ExQ	Question	Applicant's Response	7000 Acres Response
Q1.1.1	<p>Recent Government publications and consultations.</p> <p><i>Can IPs comment on the implications for their cases of the most recent Government publications including:</i></p> <ul style="list-style-type: none"> • <i>The Department for Energy Security and Net Zero Policy Paper Powering Up Britain, and the complementary papers Powering UP Britain: Energy Security Plan and Powering UP Britain: Net Zero Growth Plan; and</i> • <i>The Department for Energy Security and Net Zero consultation on the revised energy National Policy Statements 'Planning for new energy infrastructure: revisions to National Policy Statements'</i> 	<p>The UK Government's Powering Up Britain Strategy, Powering Up Britain: Energy Security Plan and Powering Up Britain: Net Zero Growth Plan sets out how the UK will achieve energy security, promote green growth and meet its net zero targets.</p> <p>Powering Up Britain was published in March 2023 to presents the most up to date information on the Government's energy strategy. It recognises the huge potential solar generation can have in decarbonisation and emphasises the need to maximise the deployment of g

**Figure 8-2: Deploying 35GW of large-scale solar alongside government offshore wind ambitions (40GW) meets anticipated seasonal demand levels**

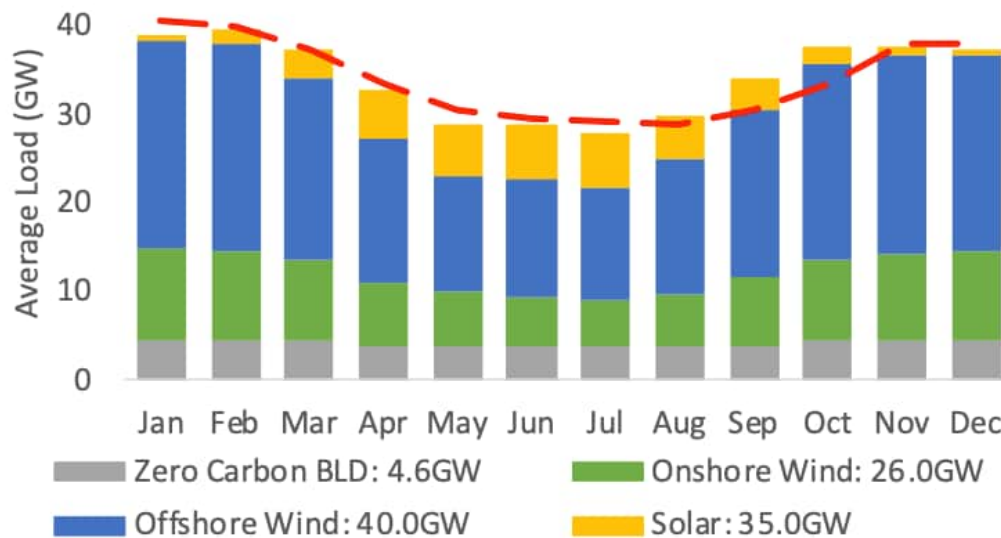
ExQ	Question	Applicant's Response	7000 Acres Response
	<p>supporting commentary in paragraphs 8.8.10 to 8.8.14.</p> <p><i>1. Provide further details of the methodology and evidence used in this model and the resulting Figure 8.2 [APP-004], including any relevant assumptions and limitations.</i></p> <p><i>2. What level of certainty can be attached to the model, taking account of any assumptions and limitations within it?</i></p>		<p>“solar will smooth seasonal variations in total GB renewable generation”, without being honest about the significant challenges solar creates through its highly variable output is disingenuous.</p>
Q1.1.14	<p>Transfer of energy to the national grid</p> <p><i>My understanding is that a BESS is needed to control the transfer of energy to the national grid because of the fluctuating quantities of energy generated by the solar panels:</i></p> <p><i>The BESS could thus be necessary development</i></p>	<p>(i) The BESS will provide Ancillary Services which are essential to support the smooth functioning of the grid. The BESS will also help National Grid Electricity System Operator (NGESO) balance supply and demand by participating in the Balancing Mechanism. Assets to provide these functions (by providing Ancillary Services and operating in the Balancing Mechanism) are necessary to address the impacts of increasing renewable energy sources (RES) which displace the carbon intensive means of generation that have traditionally provided these functions. The need is expected to grow as a result of the</p>	<p>The Applicant has described how the BESS will participate in the Balancing Mechanism – which will allow trading of energy not associated with that produced by the solar scheme.</p> <p>Buying cheap energy from the grid (e.g. periods of high wind), and selling back at peak times will be the primary source of</p>
